Sunnica: Schedule of Changes to Framework CTMP and Travel Plan.

CABLE ROUTE, SITE ACCESS J & K
 (CR-J)&(CR-K) A142/NEWMARKET ROAD
 TEMPORARY TRAFFIC SIGNALS
 AND VISIBILITY

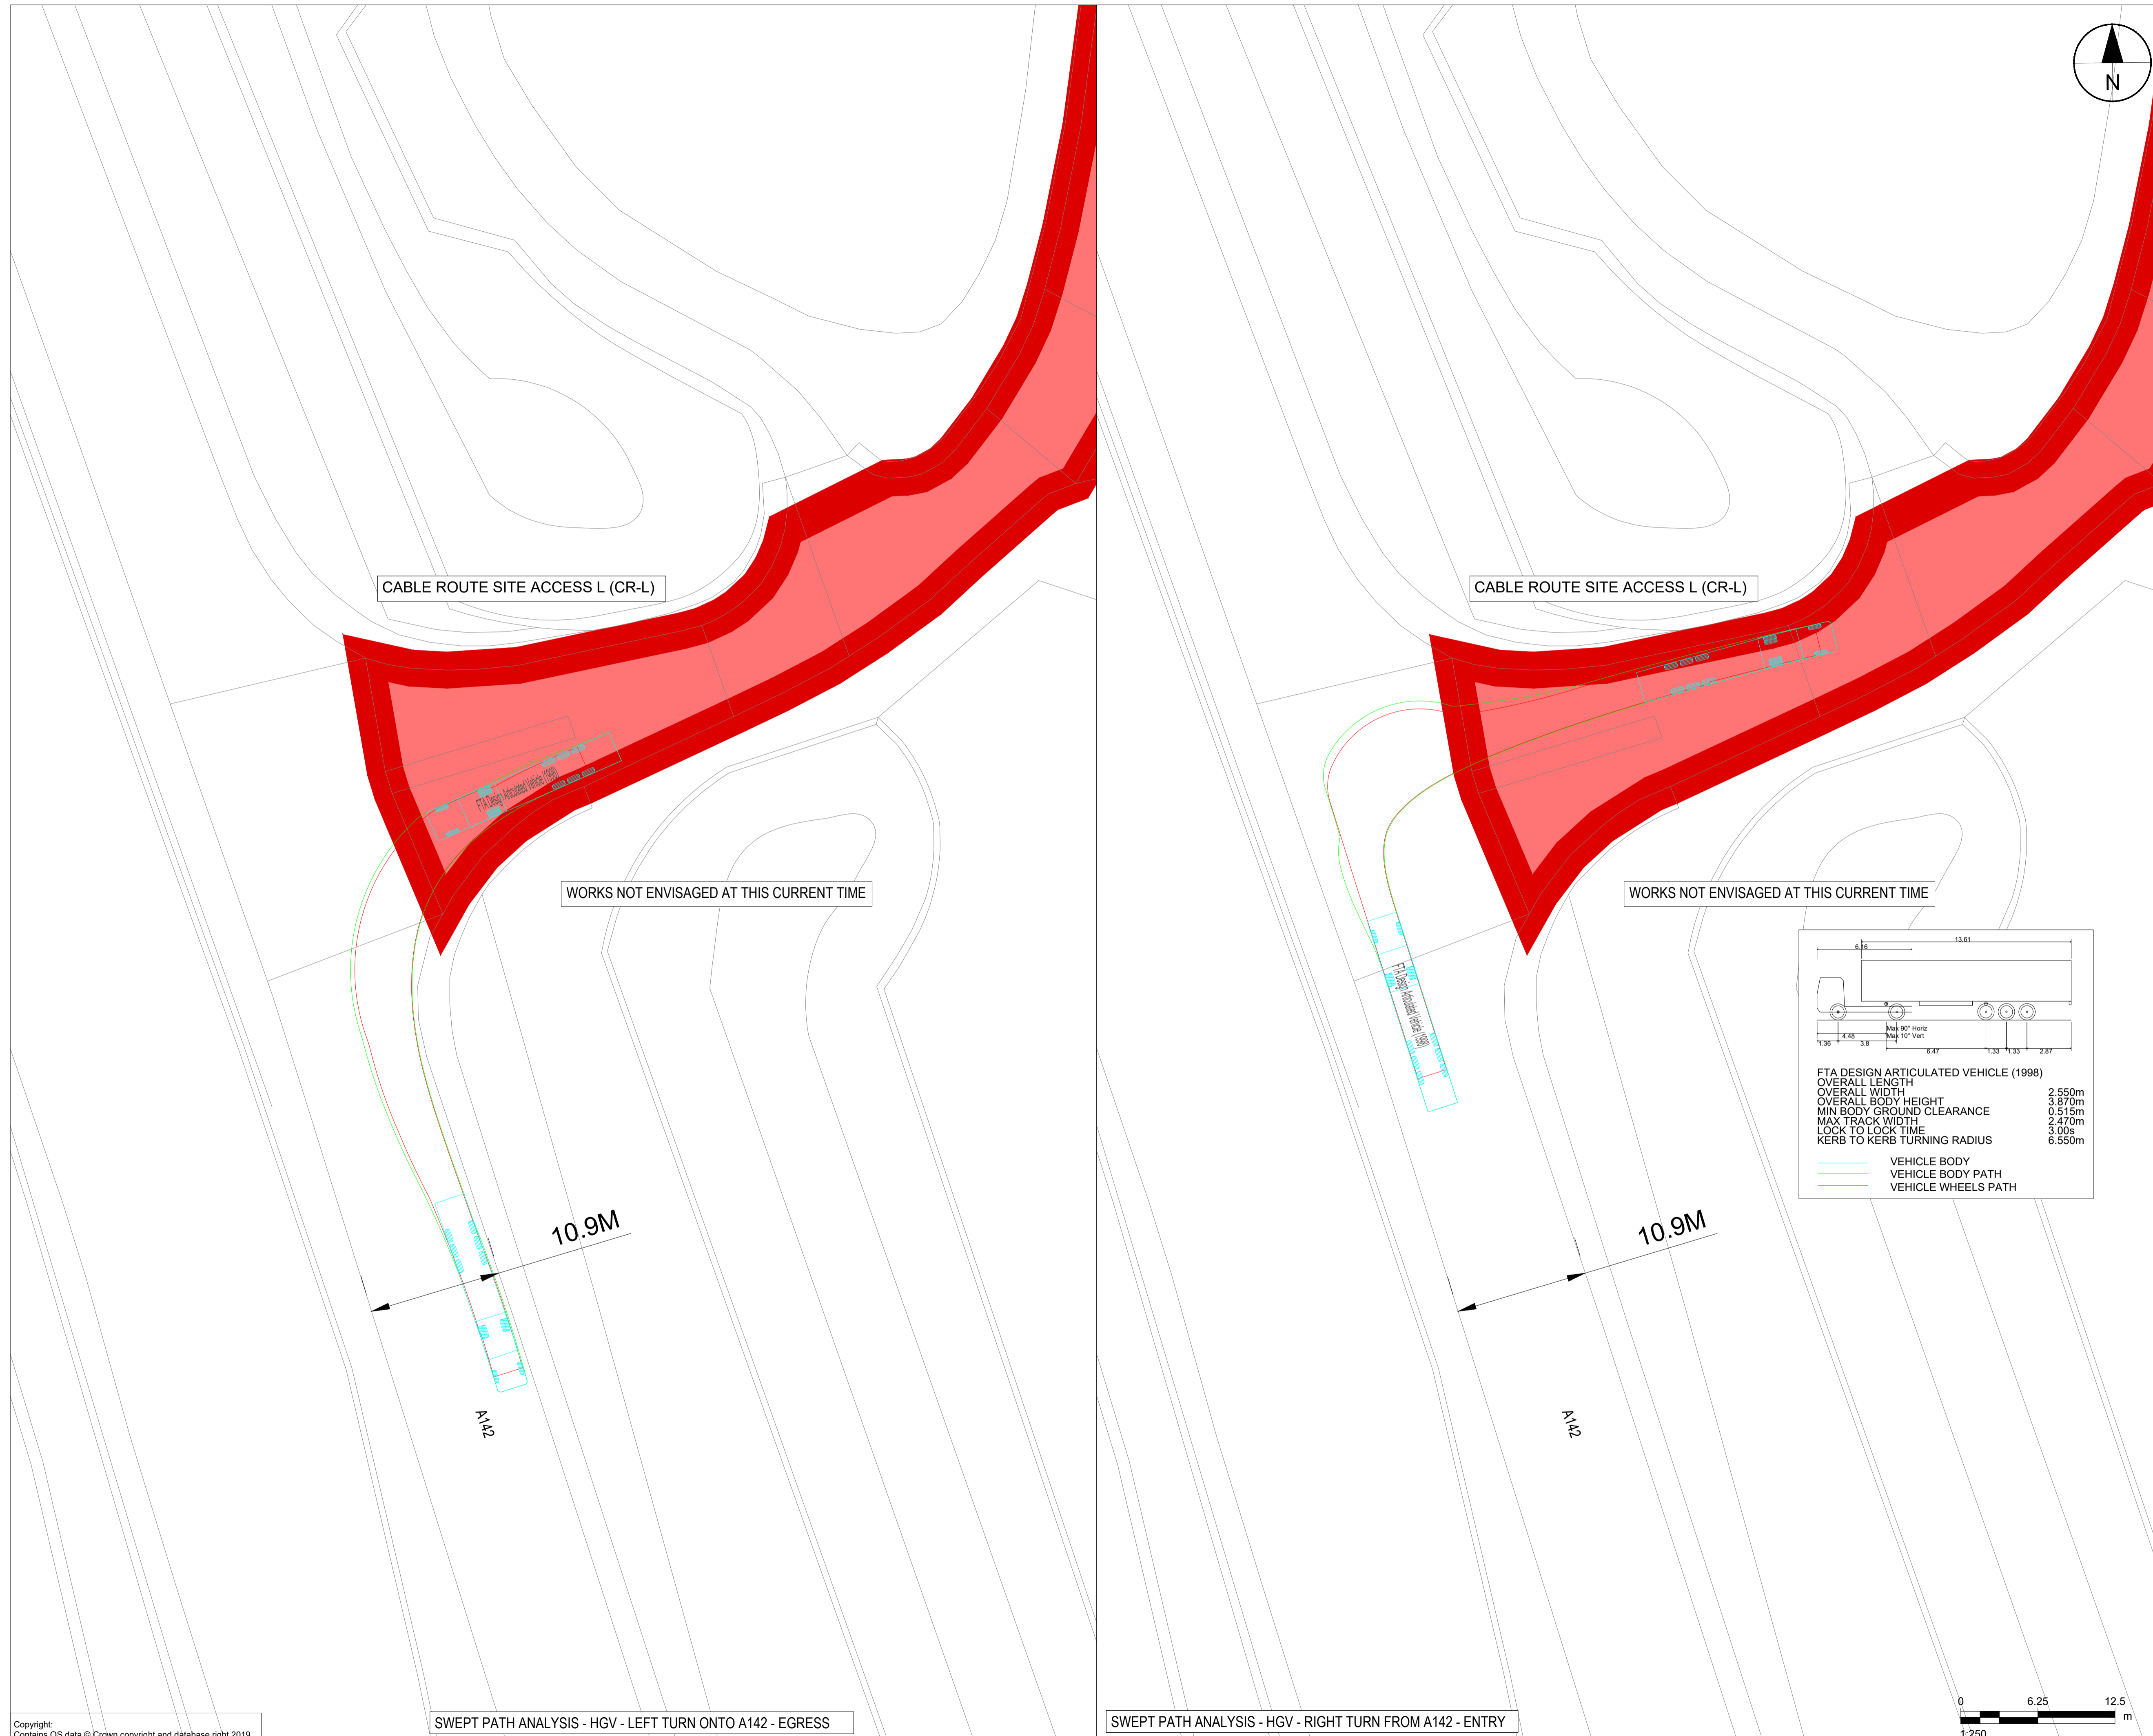
| 11 | Concerns at the A142 for Cable Route Site Access J on A142 and the swept path analysis shown crossing over onto the opposite side of the carriageway and the current site access arrangement, given the location to the A142 roundabout (circa 100m to the east), and the rear shunts with HGV turning into the site access | <p>The Applicant will:</p> <ul style="list-style-type: none"> • Provide a drawing to show additional space for the left turn movement and to demonstrate that the swept path of the HGV will not cross over onto the opposite side of the carriageway. • A RSA which will consider the rear shunts issue. |
